**Harbourside Shopping Centre Redevelopment - Darling Drive, Darling Harbour
(SSD-49295711-Mod-2)**

Thank you for your correspondence via the Major Projects Portal on 2 September 2024, requesting Transport for NSW (TfNSW) to review and comment on the above.

Expansion of land uses on level 1

Figure 6: Promenade Indoor and Outdoor Dining and L1 Event Use – Night – R8 and R12

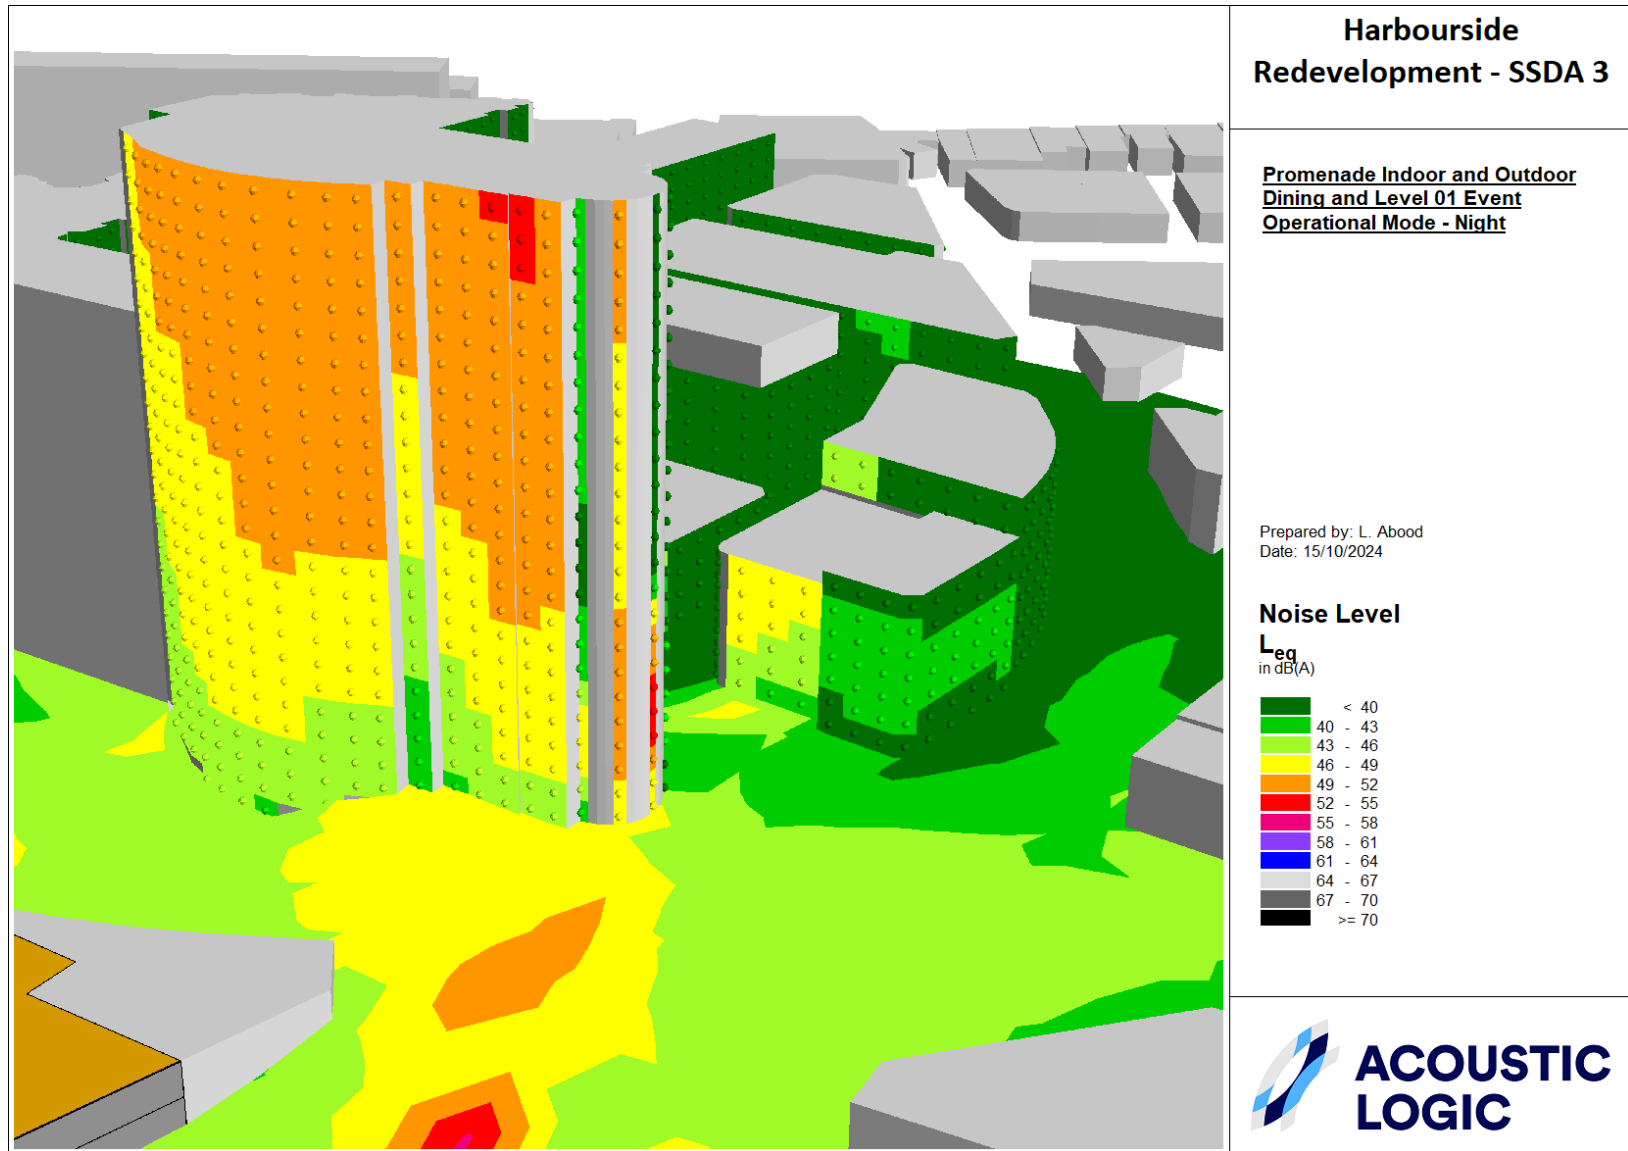
The above modification proposes expansion of land uses to include event and conference uses for the commercial component of the development. The Transport Assessment Report prepared to support the modification proposal states that:

- 37% of patrons accessing the event / conference space would use point to point transport; and
- Typical events and conferences of a business or corporate nature typically occur during working hours, and thus patrons are unlikely to be travelling on the road network during the commuter peak hours.

- Drop-off and pick-up movements from other users within the building and the Precinct need to be included for the travel mode study; and
- Patrons attending events and conferences during working hours would have the potential to arrive / depart the site during the commuter peak periods.

It is requested that the applicant demonstrates as part of the Response to Submissions that the drop off / pick-up area will have adequate capacity to accommodate the additional demand likely to generated by the proposed event and conference uses, taking into consideration the commuter peak as well as other concurrent events within the precinct.
